OXFORDSHIRE COUNTY COUNCIL'S RESPONSE TO CONSULTATION ON THE FOLLOWING DEVELOPMENT PROPOSAL

Application no: 21/03558/OUT

Proposal: OUTLINE - Residential development for up to 250 dwellings including affordable housing and ancillary uses including retained Local Wildlife Site, public open space, play areas, localised land remodelling, compensatory flood storage, structural planting and access.

Location: Land On The North East Side Of Gavray Drive Bicester

(see Drawing No. 239\_P11-Access & Movement Parameter Plan)

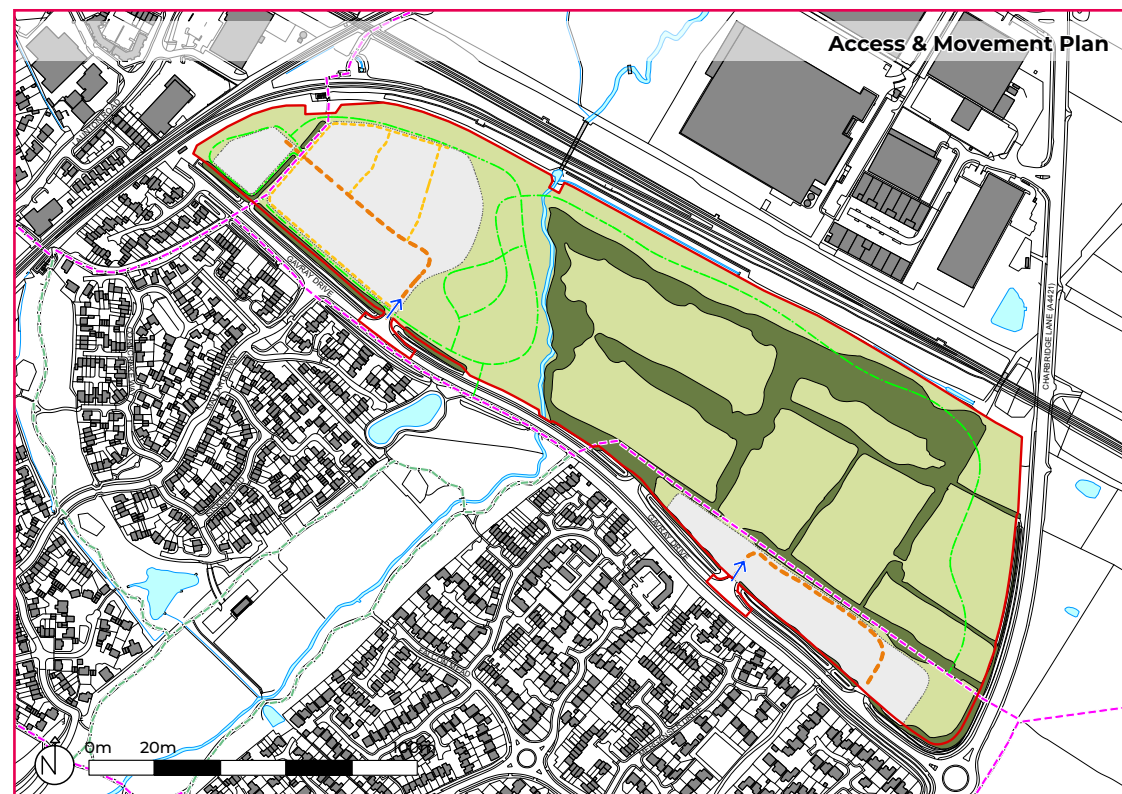
Currently there is a shared use footway / cycleway on the southern side of Gavray Drive, this is separated by the use of a white line. National standards set out in the LTN 1/20 Cycle Infrastructure Design Guide (adopted in 2020) sets out that this type of facility should be avoided in locations such as this due to the potential for conflict between pedestrians and cyclists. This existing facility also does not meet the minimum width requirement for such a facility, even where they are permitted under the LTN 1/20, so are inadequate to serve the proposed new development.

The applicant has also proposed a short section of 3m wide shared use footway on the northern side of Gavray Drive between the access to the eastern development plot and the A4421 in order to provide a route towards future bus stops which are to be provided on the A4421 (see public transport comments on this) and also for those pedestrians and cyclists travelling north on the A4421. Again, this type of provision should be avoided under the LTN 1/20 standards.

In line with the national LTN 1/20 Cycle Infrastructure Design standards, segregated cycle facilities are required to serve the development on Gavray Drive. Given that the road is fairly wide and very straight it would not be suitable for most cyclists to share the carriageway with general traffic. The county council therefore requests that the shared use footway on Gavray Drive is upgraded to provide segregated cycle lanes with a buffer between the cycle lanes and carriageway to be retained.

I note that the access junctions into the site are to accommodate pedestrian / cycle priority measures. Such measures are required however these would need to be amended to take account of the type of pedestrian and cycle facilities to be provided on Gavray Drive. The junction radii at the two access junctions should be decreased so that they are more amenable for pedestrians and cyclists.

Crossings will be required at each of the site access junctions in order to provide connections through to Langford Village and the railway crossing. Informal crossings are likely to be sufficient at these locations.

- Site access junctions with Gavray drive including;
 - tighter kerb radii in line with Manual for Streets standards
 - pedestrian and cycle priority over the access junctions
 - provision of informal crossing points at each site access junction
- Signalised pedestrian crossing on Wretchwick Way, north of the Gavray Drive / A4421 roundabout junction where the Public Right of Way exits the east of the development site onto Wretchwick Way
- Parallel crossing over the Gavray Drive arm of the Gavray Drive / A4421 roundabout junction
- Segregated pedestrian and cycle facilities on Gavray Drive in line with standards set out in the LTN 1/20.
